Our Ref: F2006/00524

18 March 2016

**STATE SIGNIFICANT DEVELOPMENT APPLICATION: REFURBISHMENT OF ELECTRICAL ENGINEERING BUILDING, UNSW (SSD 7370)**

Figure 12 – North Block rooftop plant façade

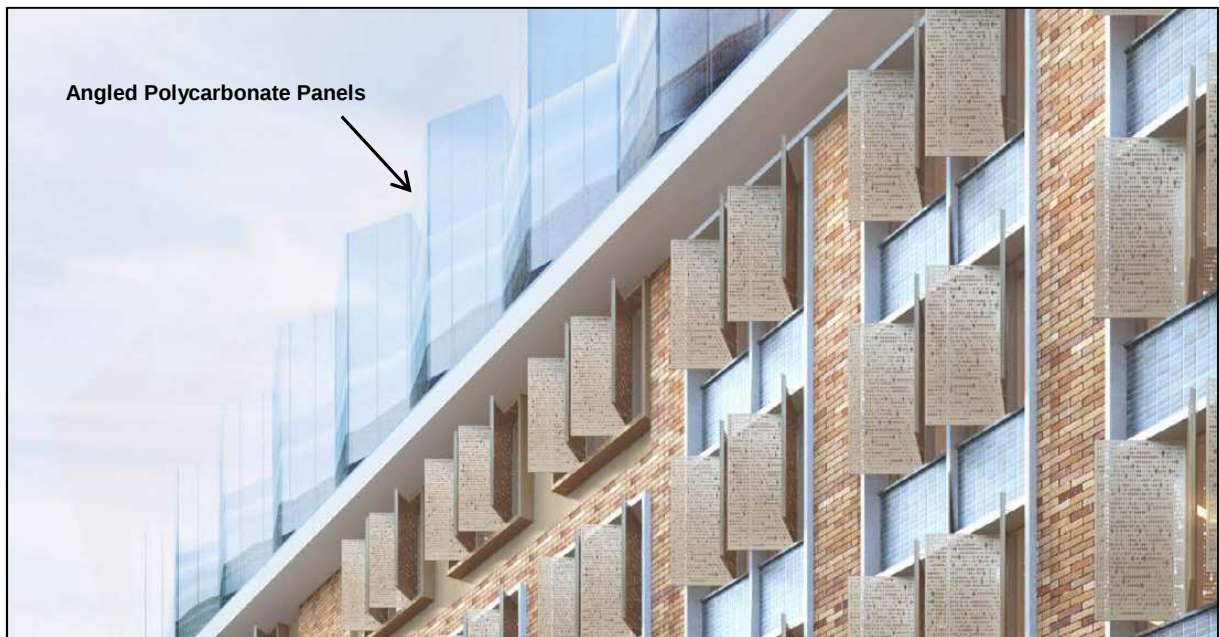
The proposal involves locating plant and equipment on the roof of EEB. The EIS indicates that future operational noise levels are unclear at this stage as final selection of plant and equipment is yet to be decided. In Council's view, it would be premature to approve the rooftop plant and equipment without certainty that its operation will not give rise to an 'offensive noise' as defined in the Protection of the Environment Operations Act 1997 and Regulations.

The EIS notes that noise controls will be incorporated within the design of the rooftop plant and that these controls may include physical barriers, enclosures, acoustic louvres, sound absorptive panels and the like. If such measures are required to mitigate acoustic impact it will be necessary to understand their likely configuration and design in order to assess visual impact, given the prominent location of these structures on the roof of the EEB.
